**From:** Linda Griffiths  
**Sent:** 02 January 2024 10:01  
**To:** DC Support  
**Subject:** FW: 23\_03073\_HYBRID (Ludlow Road Kingsmere Extra Care Home)

**From:** Paul Troop <pault@gclaw.co.uk>  
**Sent:** Tuesday, January 2, 2024 5:32 AM  
**To:** Linda Griffiths <Linda.Griffiths@Cherwell-DC.gov.uk>; White, Joy - Oxfordshire County Council <joy.white@oxfordshire.gov.uk>; Will.Madgwick@oxfordshire.gov.uk; JacquiCox (OCC) <jacqui.cox@oxfordshire.gov.uk>  
**Cc:** chair@bicesterbug.org  
**Subject:** 23\_03073\_HYBRID (Ludlow Road Kingsmere Extra Care Home)

Drawing Title: Proposed Site Layout Plan

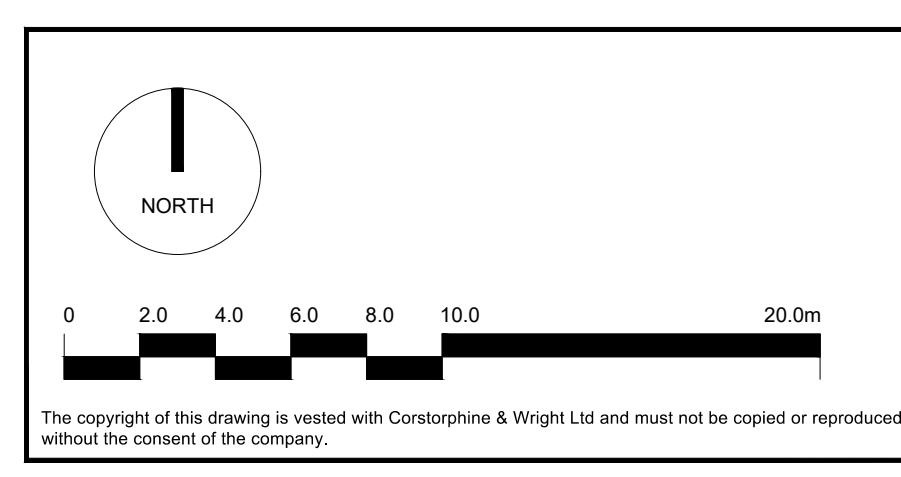
- The location of the bike parking seems inaccessible. It would seem preferable to locate this closer to the access points to the development and building.

- The bike parking seems small given the size of the development. Given the type of provision, it would seem that double stacked parking would not be appropriate here. This will require a more sizeable footprint. In addition, the cycle parking seems only designed for standard bikes, not adapted, cargo, tricycles, or other forms of wheeling. Given the nature of the development, this needs to be rethought to accommodate a wider range of cycles.

Insert 3.1 Proposed Pedestrian Connection

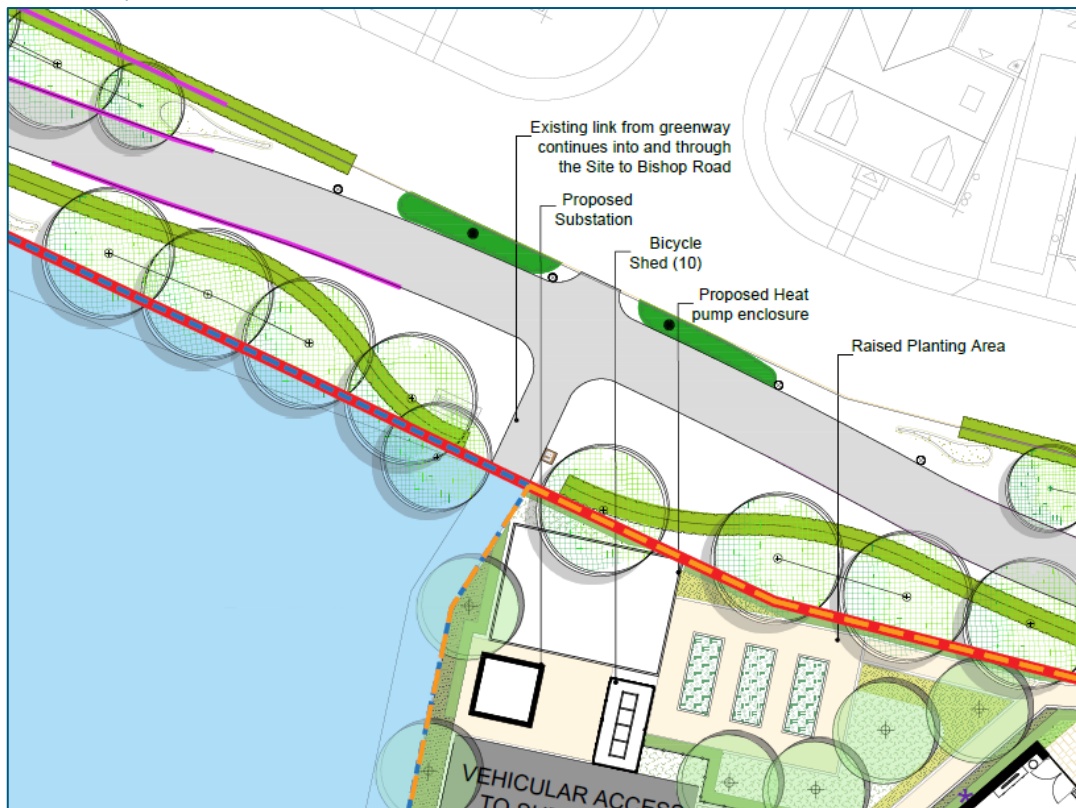
- Many of the cycle paths around Kingsmere and in the proximity of the site have access barriers that are no longer recommended and which amount to an obstacle to disabled and vulnerable users as well as users of non-standard bikes. We would be grateful if confirmation was provided that nothing of this sort will be used, other than perhaps a single post in the centre of any access that leaves adequate space either side for pedestrian, disabled, and cycle access.

- We would be keen to ensure that the permeable access is included in the design and access statement.
